District: Cherwell

Application No: 19/01777/DISC

Proposal: Discharge of condition 5 (travel plan and draft routeing agreement) of 18/02169/F

Location: Camp Road Upper Heyford

Figure 4-3 Current and Proposed Public Rights of Way

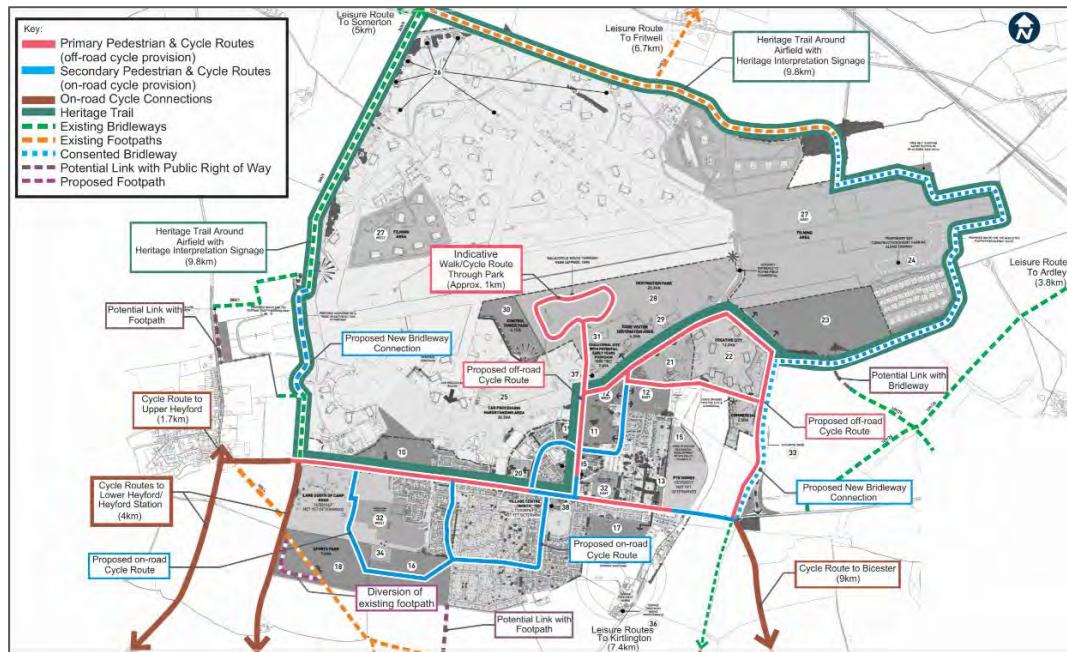
Section 4.3 of the Travel Plan references the network of public rights of way in the area and the value of these routes for walking and cycling journeys once the walking and riding network as illustrated in figure 4.3 is delivered.

However, the site owners have so far failed to meet the current and overdue requirements to reinstate Aves Ditch and Portway bridleways through the site and along Chilgrove Drive. This means that their potential for use as sustainable travel options is not relevant in relation to this Travel Plan. Given the direct connection between the whole site, the reopening of Aves Ditch and Portway, and this application, the owners of the site need take immediate steps to meet their responsibilities in a timely manner.

Figure 4-5 - Strava Heat Map

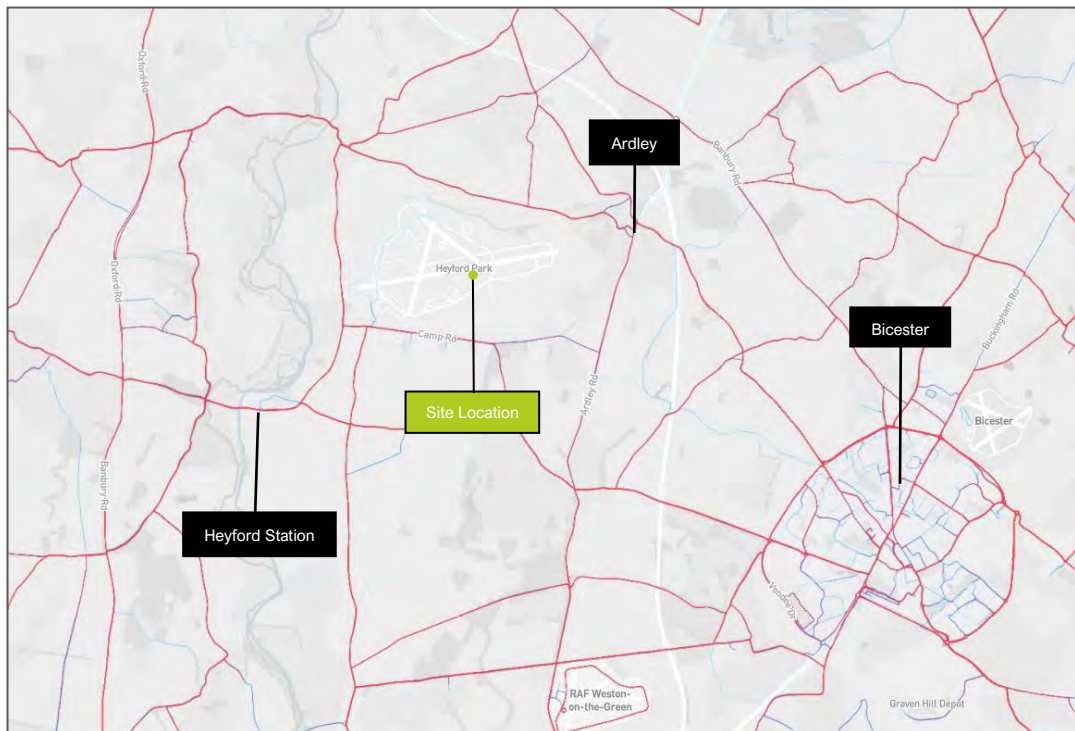
- Paragraph 4.3.16. It is not stated what a Strava Heat Map is. Figure 4.5 therefore has no meaning.
- Paragraph 4.3.32. The accessibility to bus travel for 14% of staff is considered low.

Figure 5-2 PIA Accident Data

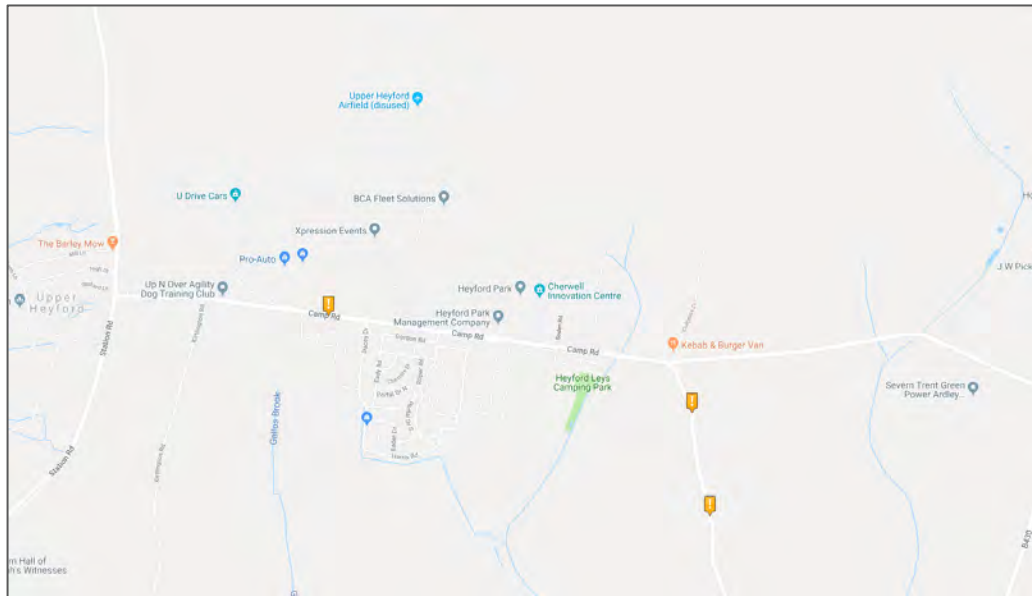
- Paragraph 5.4.1. It is usual to analyse five years of personal injury accident (PIA) data rather than only three. The County’s PIA data is more up to date than that presented on the Crash Map website.

Figure 9-1 Car Share Opportunities

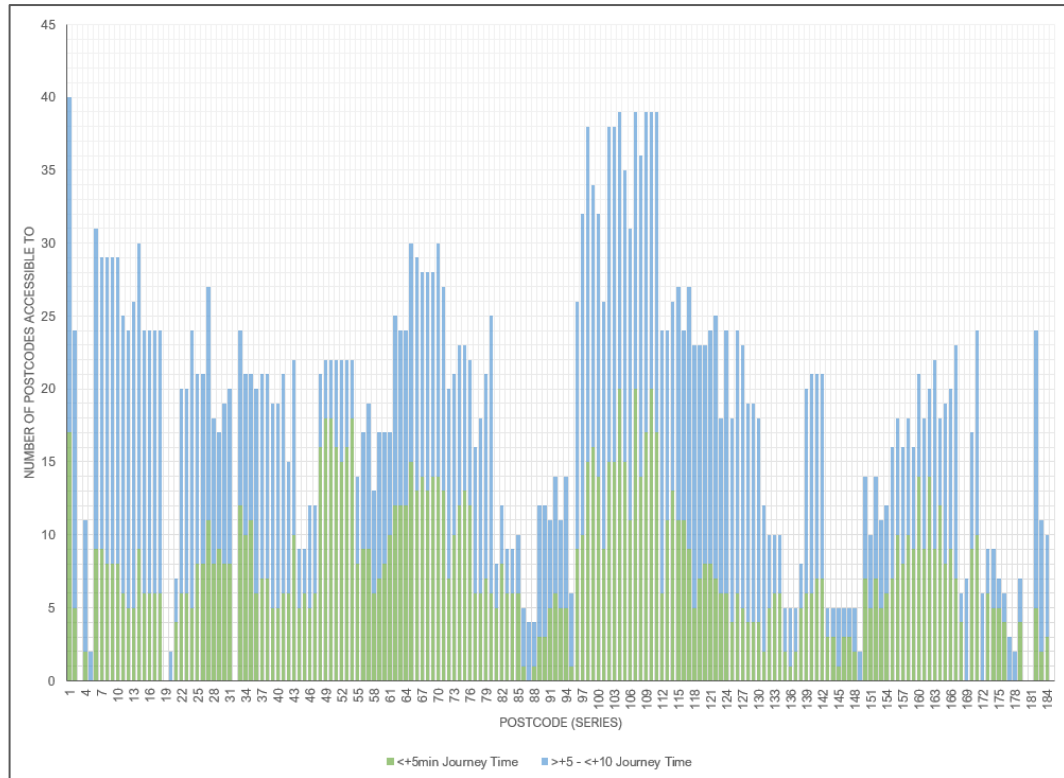
- Figure 9.1. It is not clear what this figure is demonstrating.
- Section 10. It is not clear what informal monitoring entails.
- Section 11. The action plan is not detailed enough.
